Ref: 6/2018/2665/COND
Date: 20/11/2018

HISTORIC BUILDINGS AND CONSERVATION ADVICE

RE: Ramada Hatfield, St Albans Road West, Hatfield, AL10 9RH

The application includes the submission of details pursuant to condition 4 (Part A - roof lantern, Part D - door openings and frames, Part E - window openings and frames and Part H - Rooflights to kitchen) on listed building consent 6/2017/2746/LB, dated 15/02/2018.

Fixed Rooflight Detail
1 : 10

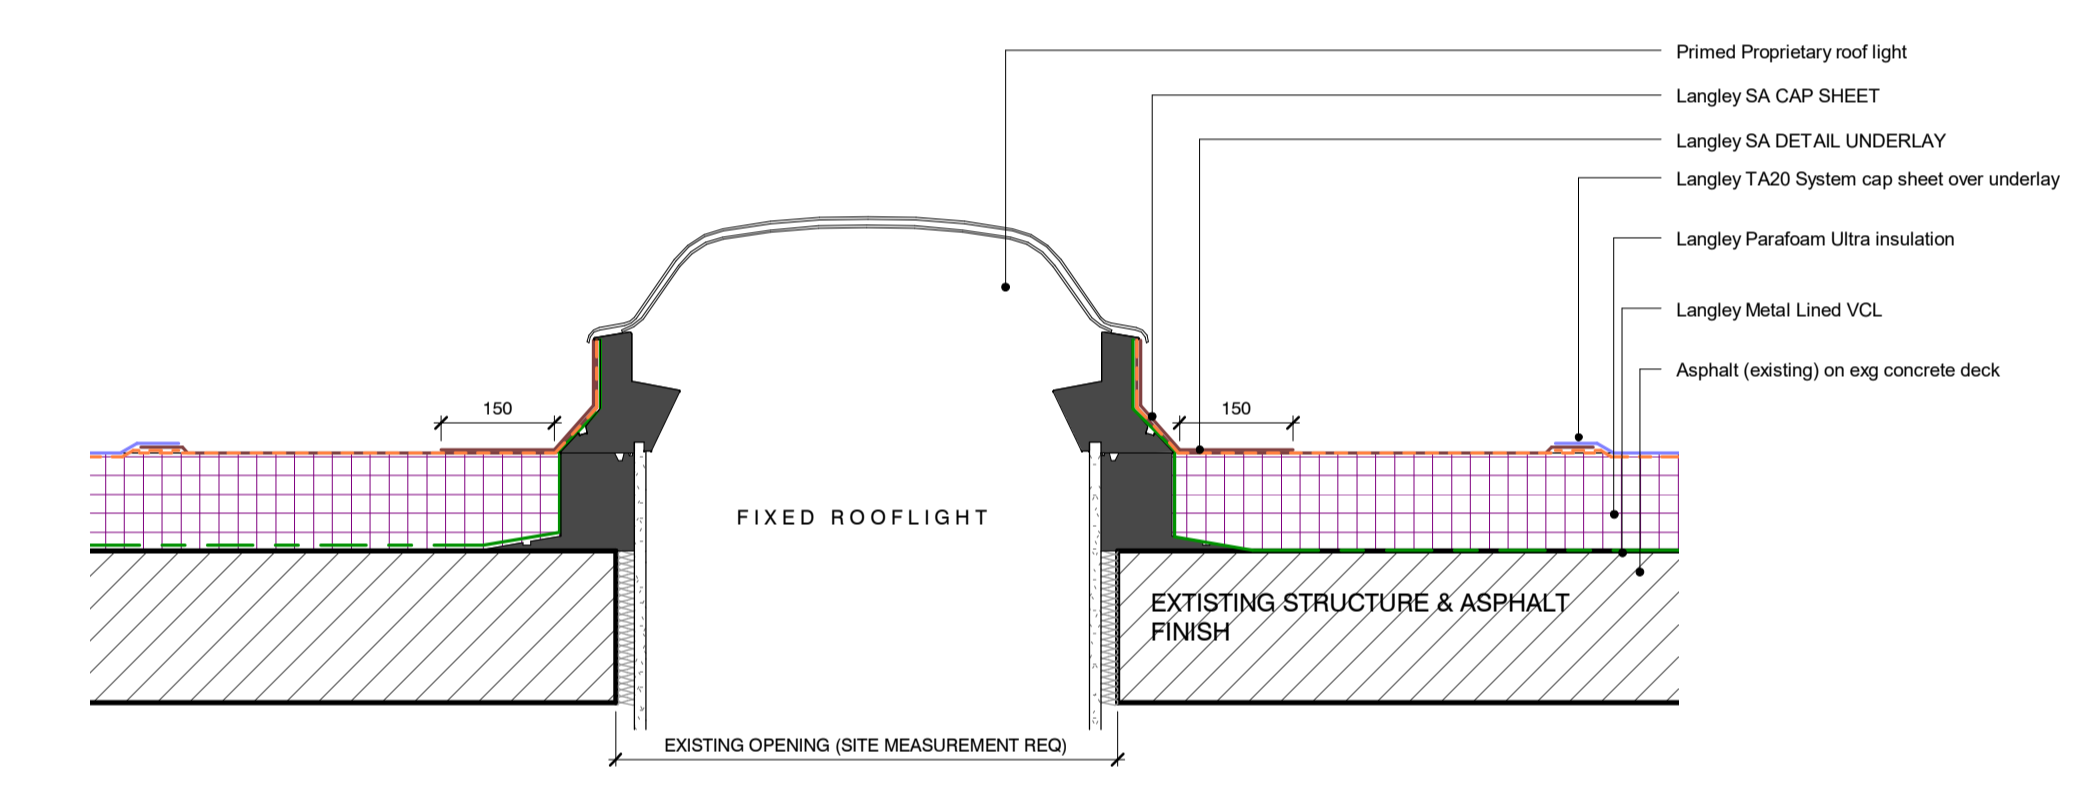
The details submitted are sufficient to discharge condition 4. The window sample has previously been inspected on site and deemed to be acceptable. However, there is a concern with regards to Part H as the height of the flagpole on the roof lantern appears to be shorter than that shown in elevation drawings submitted with the original listed building consent (e.g drawing no. COMET-STL-01-XX-DR-A-XXXX-02006 Rev. P45). The height of the flagpole should match the original.
